DEVELOPMENT REVIEW BOARD
TRANSPORTATION DEVELOPMENT

DRB Project Number: 2019-003092
Ridgecrest and San Mateo

SUBJECT: Vacation

DATE: January 8, 2020

**ALLEY VACATION EXHIBIT**  
9-25-19

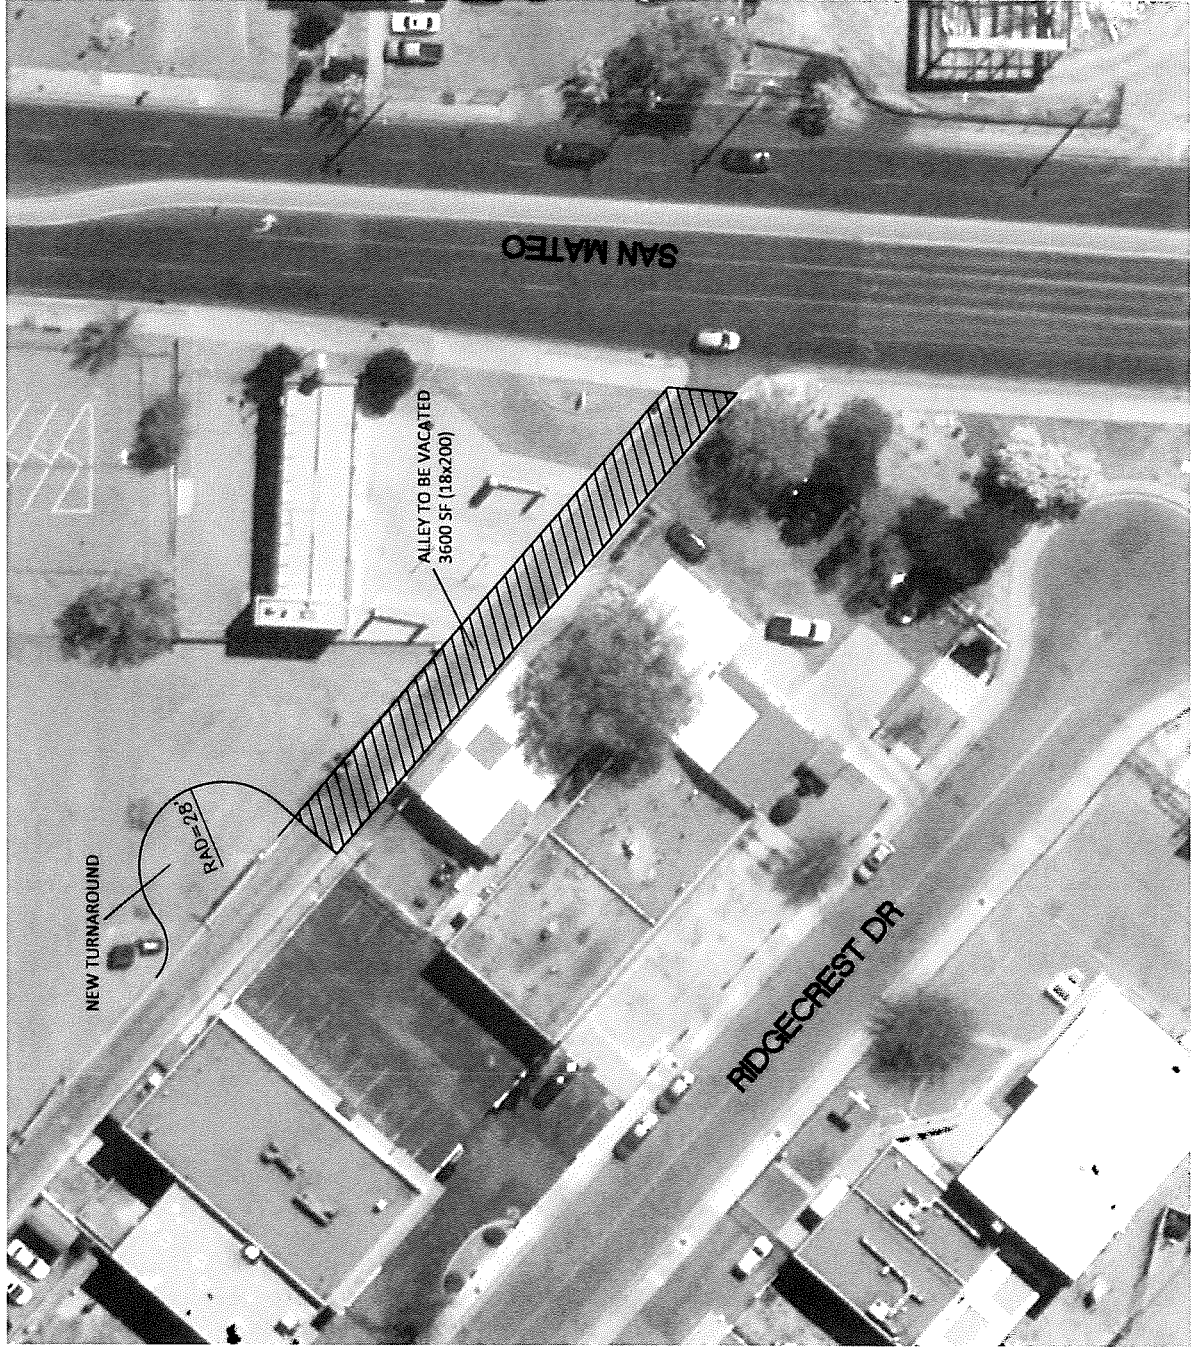
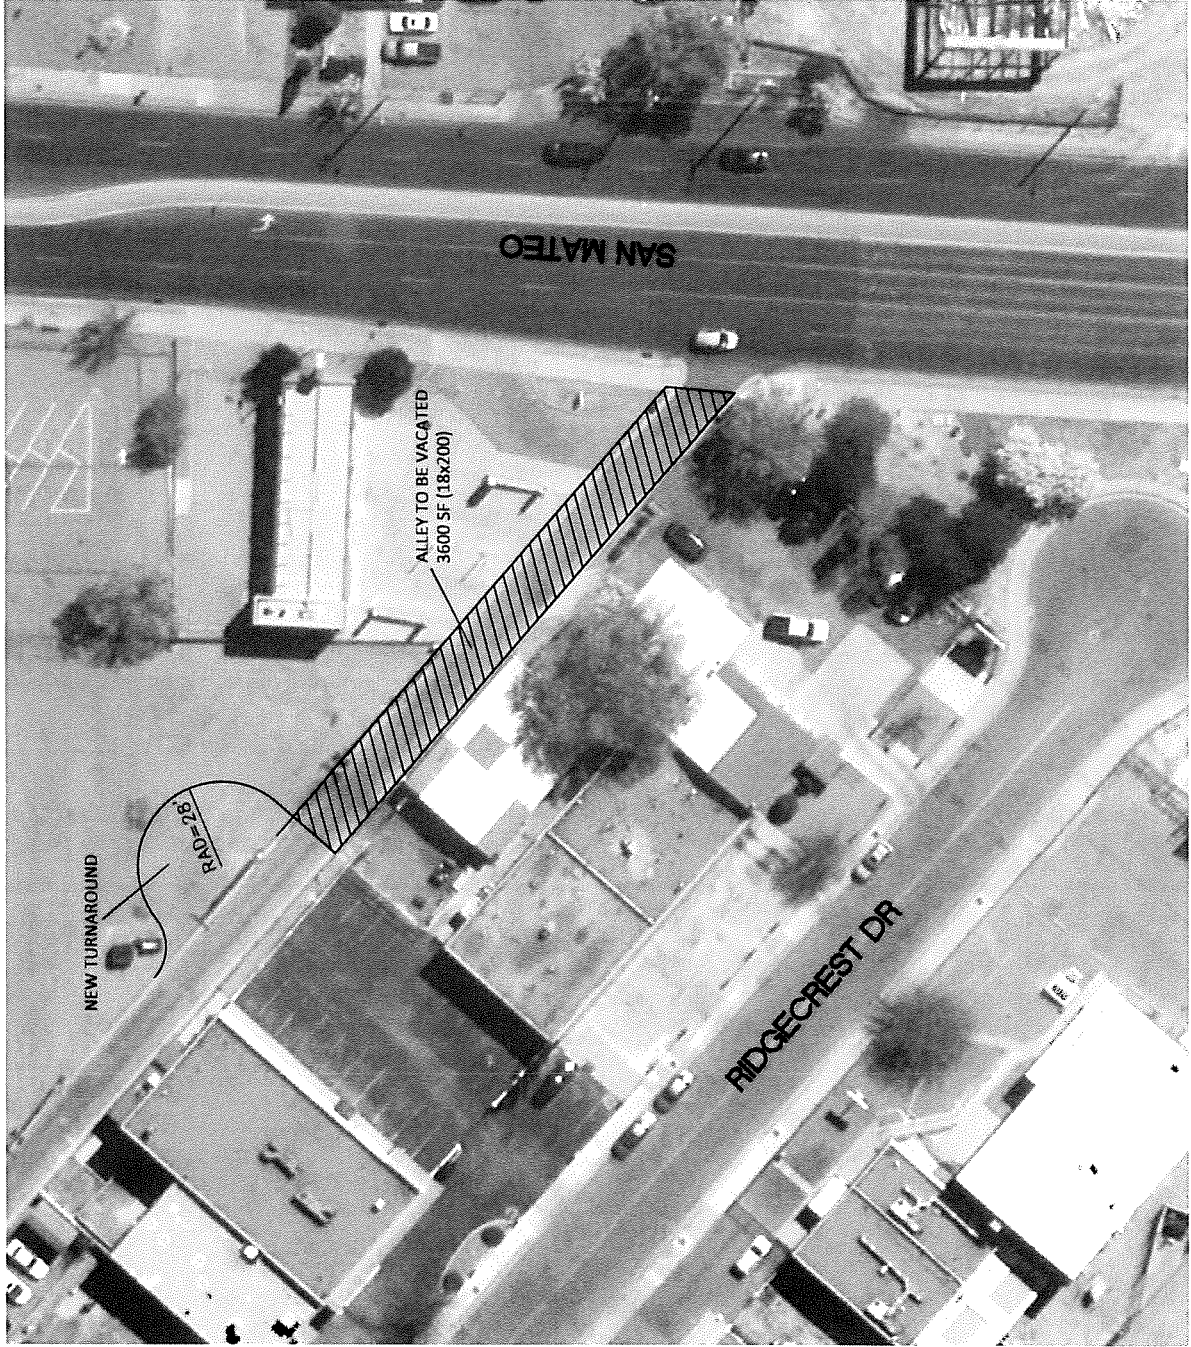
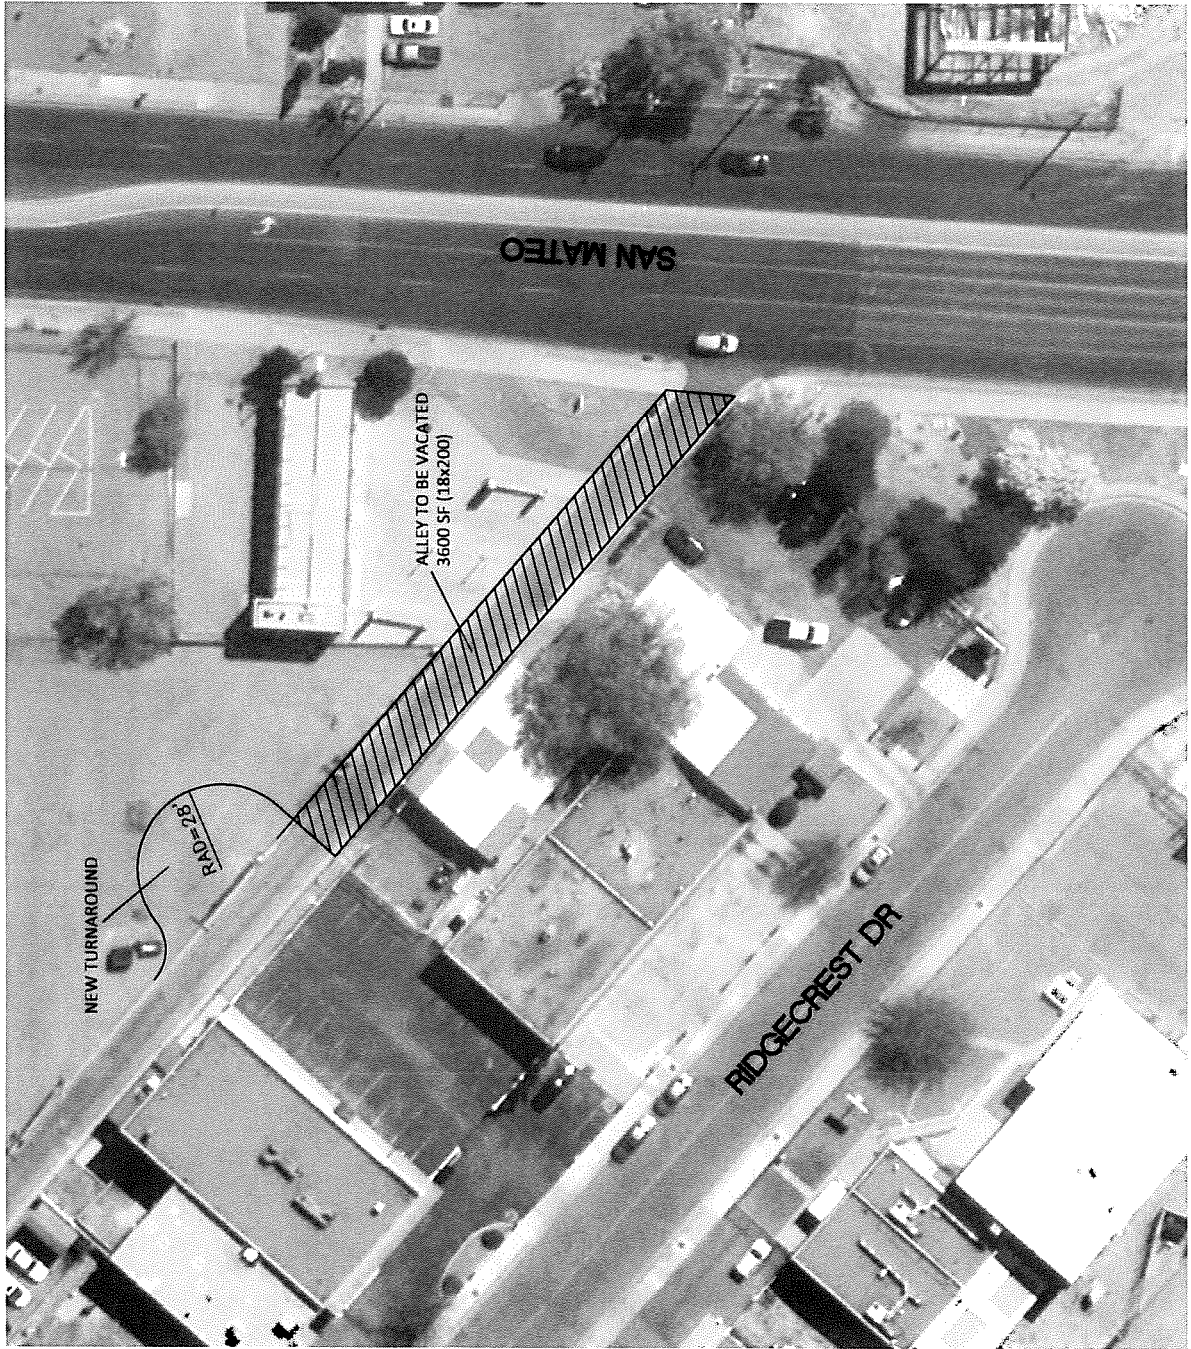
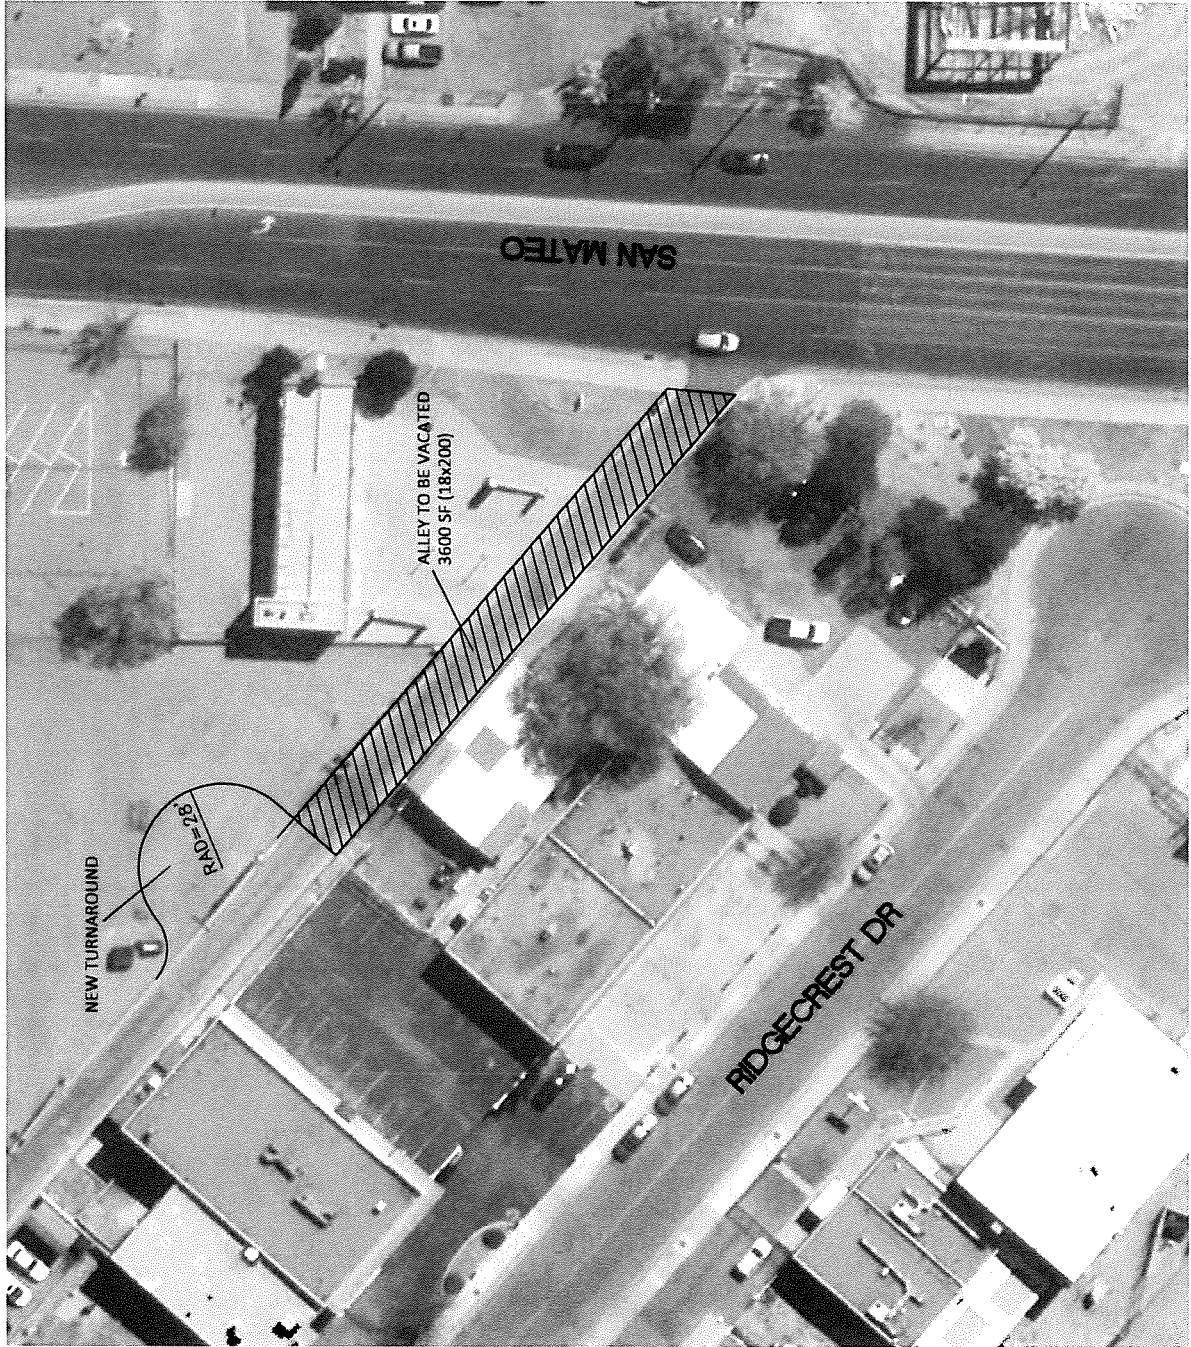
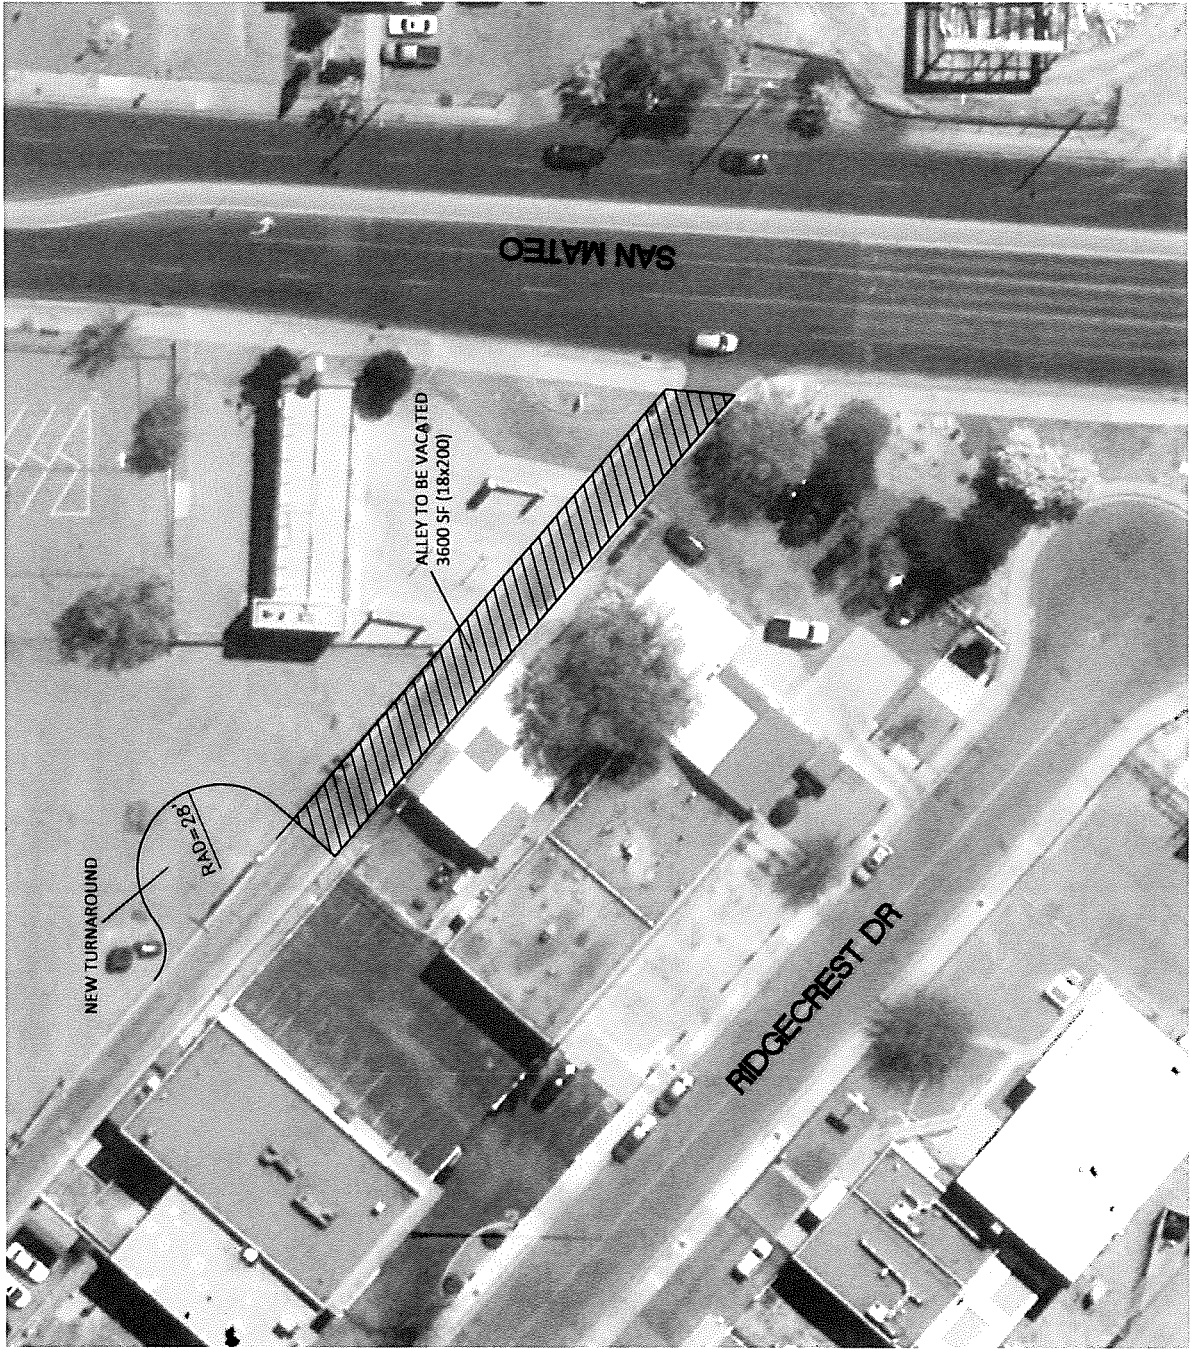
1. Transportation has no objection to the vacation.
2. Coordinate with the Fire Marshall on proposed layout shown in exhibit. The new turnaround radius combined with width of alleyway do not meet fire code standards for a road that would be over 150 feet long. Place these improvements on an infrastructure list.
